Sept. 25, 2017

RE: **Premier M.H Display Yard**
Grading Plan
Engineer's Stamp Date 9/15/17
Hydrology File: M14D012C2

Based on the information provided in the submittal received on 9/19//17 the above-referenced Grading Plan cannot be approved for Building Permit until the following are addressed:

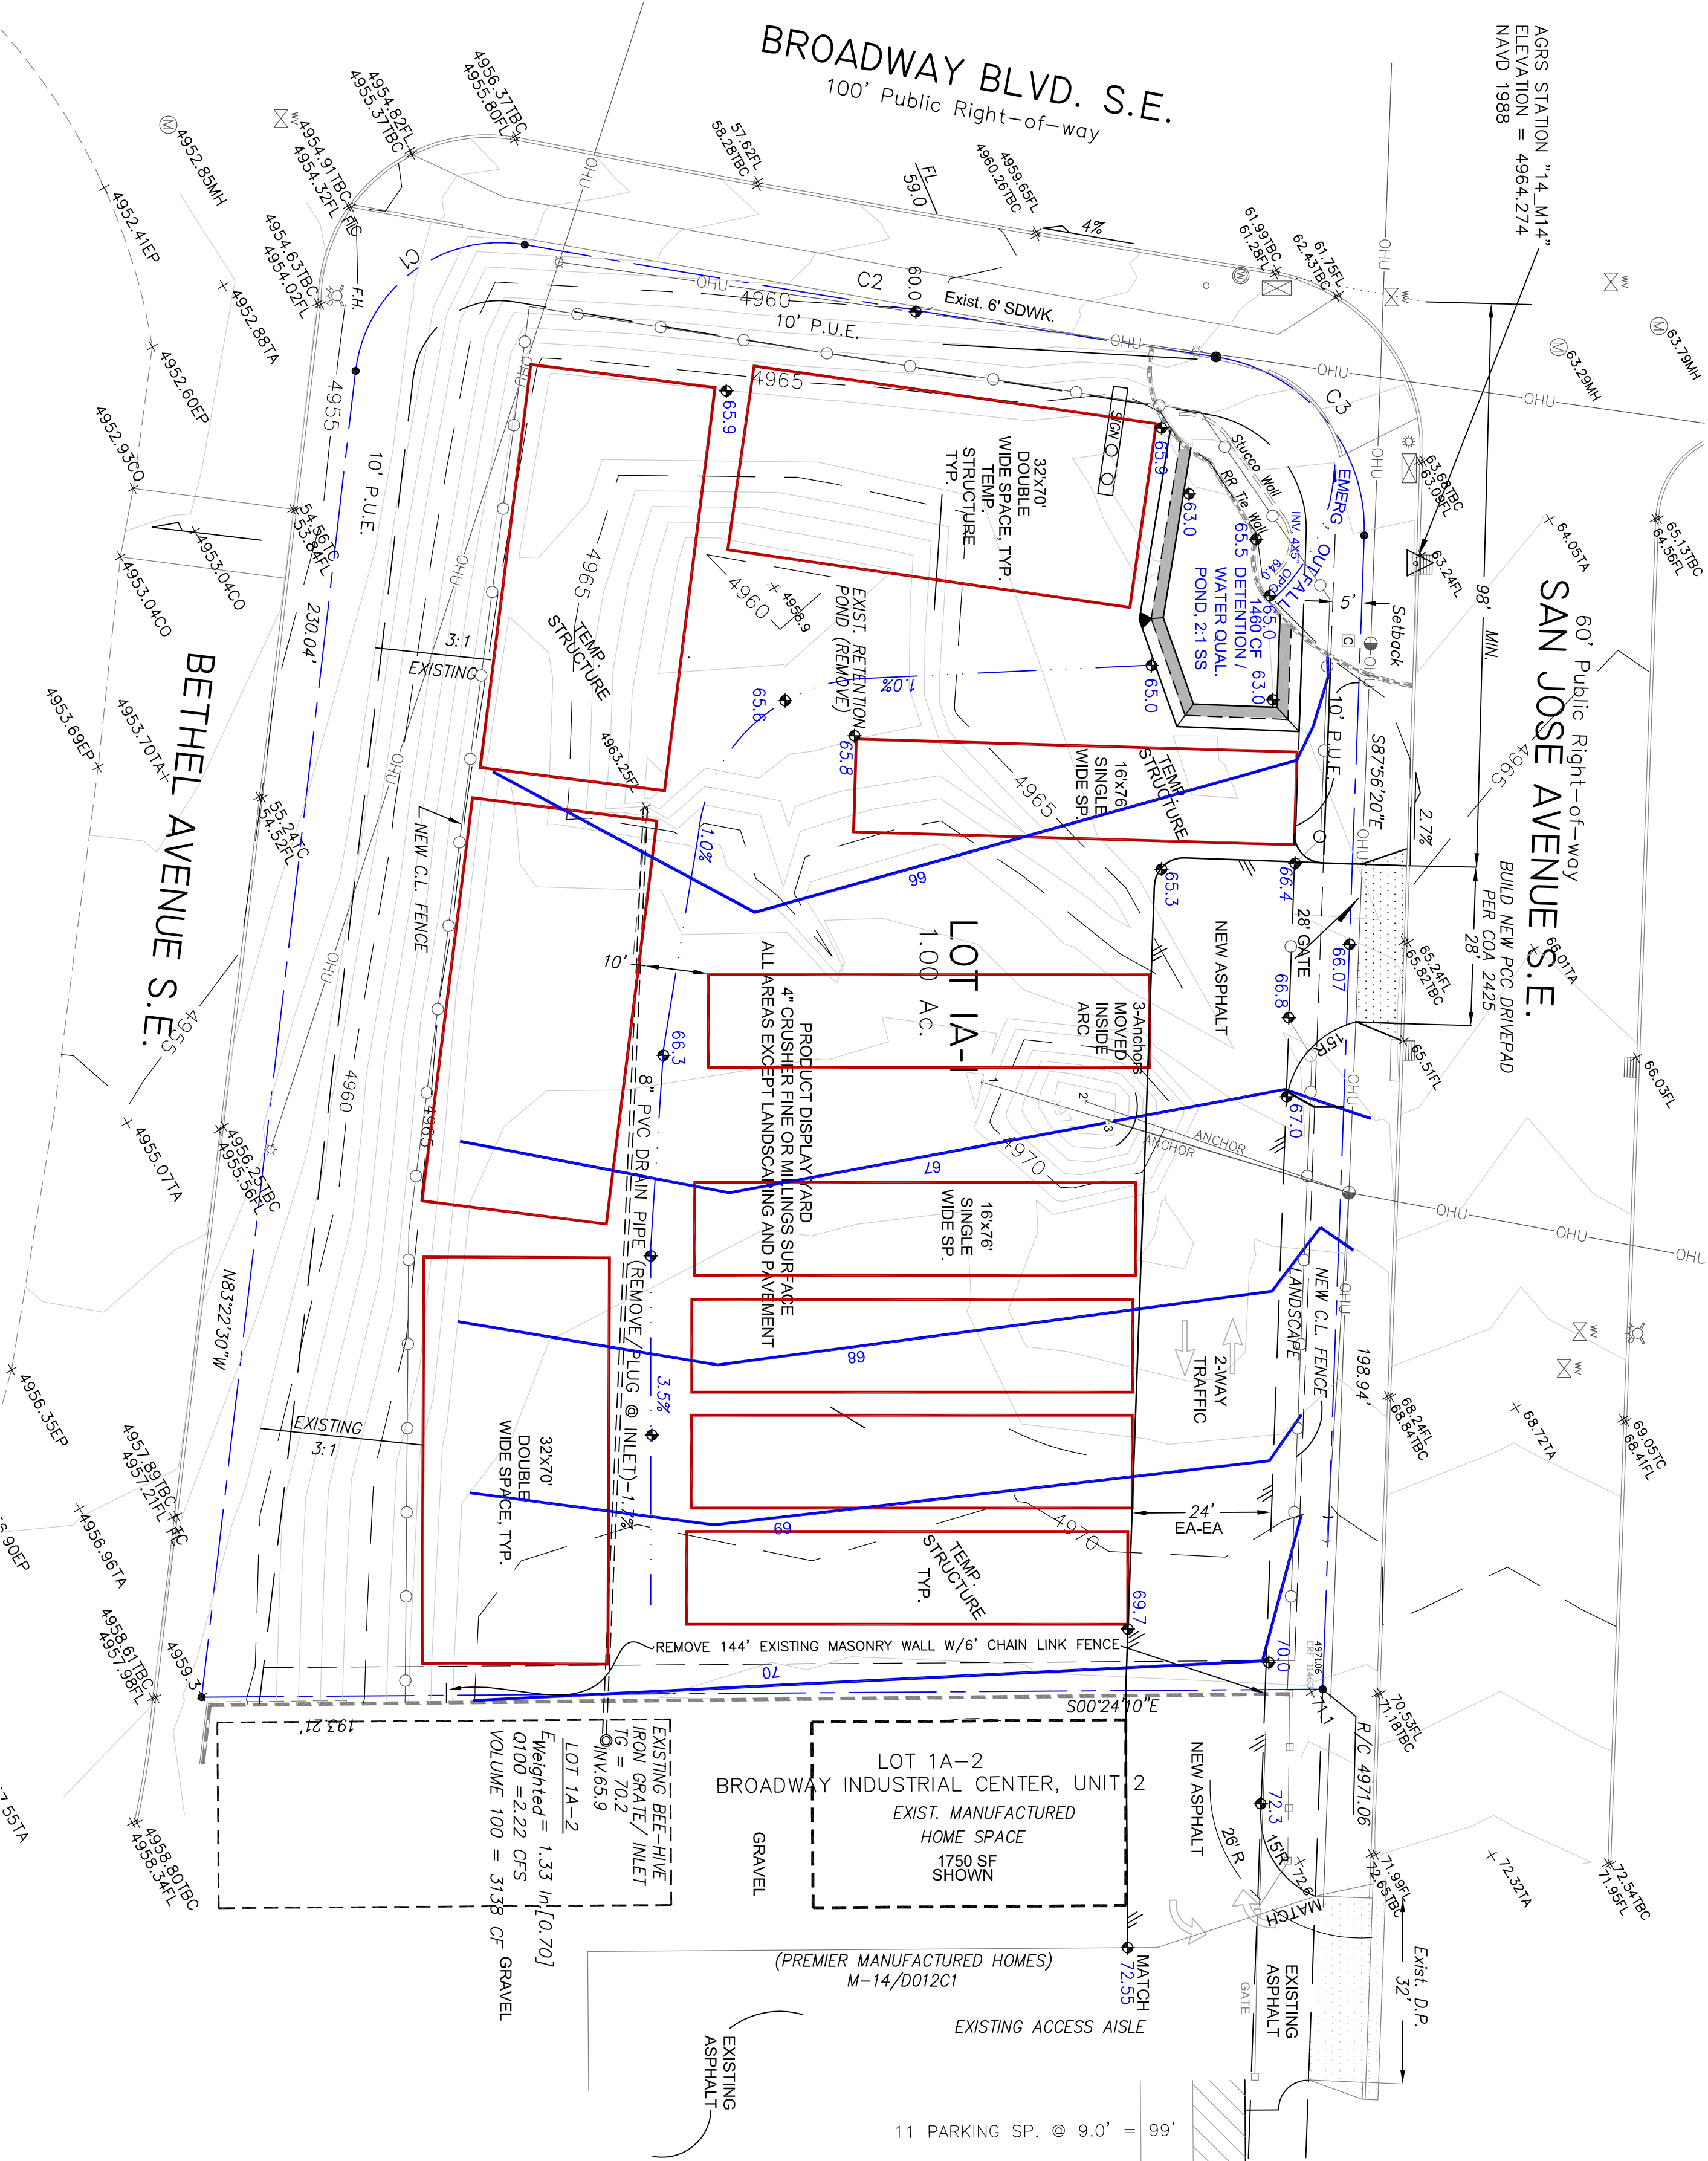
1. The hydrology presented on this plan is difficult to follow. The plan must clearly show that the pond serves both lots. One Basin map is required showing both onsite and offsite basins and the hydrology calculations for all basins must be put into a single easy to read format. The note on the pond and the "Grading and Drainage Plan" notes should both state clearly that the pond serves both lots 1-A-1 and 1-A-2. The impervious cover of the adjacent lot should be changed in the Grading and Drainage Plan notes to reflect the maximum impervious cover allowed on that lot including roof drainage from temporary mobile buildings.

2. Under "Calculations" the "Existing Conditions" section should identify the existing pond. Specifically it should state "the existing pond was designed to retain 18900 cf., the 100 year 10 day runoff from both lots 1A-1 and 1A-2.

3. Provide a copy of the Landscaping Plan by Hilltop that is referenced in the "Project Data" section to justify the use of lawn, land treatment B, in the "Calculations" section. If there is not a landscape plan then delete the reference in the Project Data section in the bottom right corner of the sheet and use only treatments C and D in the hydrology calculations.

4. Under "Calculations- Developed Conditions" present the hydrology for both onsite and offsite basins. Add a note stating that "Prior to placing more impervious cover on the lots than assumed in the calculations, the pond volume must be increased accordingly. Impervious cover includes the area of the retention pond, the area of the

asphalt and concrete paving, and the area of the roofs of the temporarily placed manufactured buildings. Failure to increase the volume in advance of placing increased cover on either lot will constitute a violation of the Drainage Covenant, in which case the City may construct increased pond volume and lien the property for the costs."

5. The spot elevations along the south property line must be lower so that slope between the curb and right of way does not exceed 2%.
6. Provide pond wall design calculations stamped and signed by a NMPE. Hydrology will review the calculations since this is a drainage structure, but the wall will also require a separate building permit. Hydrostatic forces should be assumed to act on the underside of the footing. A core trench of impervious material is needed to prevent seepage under the footing. The drainage wall must be extended to higher ground on the ends. The wall material should be changed to concrete instead of block.

7. Hydraulic calculations must be added to the plan for the emergency overflow spillway.
8. Show the existing curb on lot 1-A-2, and specify location and length of opening in the curb to allow passage of the peak 100 year flow rate and provide hydraulic calculations for the opening. Extend the swale limits all of the way to the opening in the existing curb.

9. Offsite basins, lot 1A-2, must be clearly shown on the plan (or on a separate basin map) using a base map that includes property lines contours, and all storm drains, roads, C&G, ditches, and berms as necessary to support the chosen location of the basin boundaries. Flow arrows should be shown on the map indicating concentrated flow paths especially at the point of discharge from each of the basins. Reference to the previously approved plan for Lot 1A-2 should remain on the plan, but this plan must stand on its own and include all calculations.
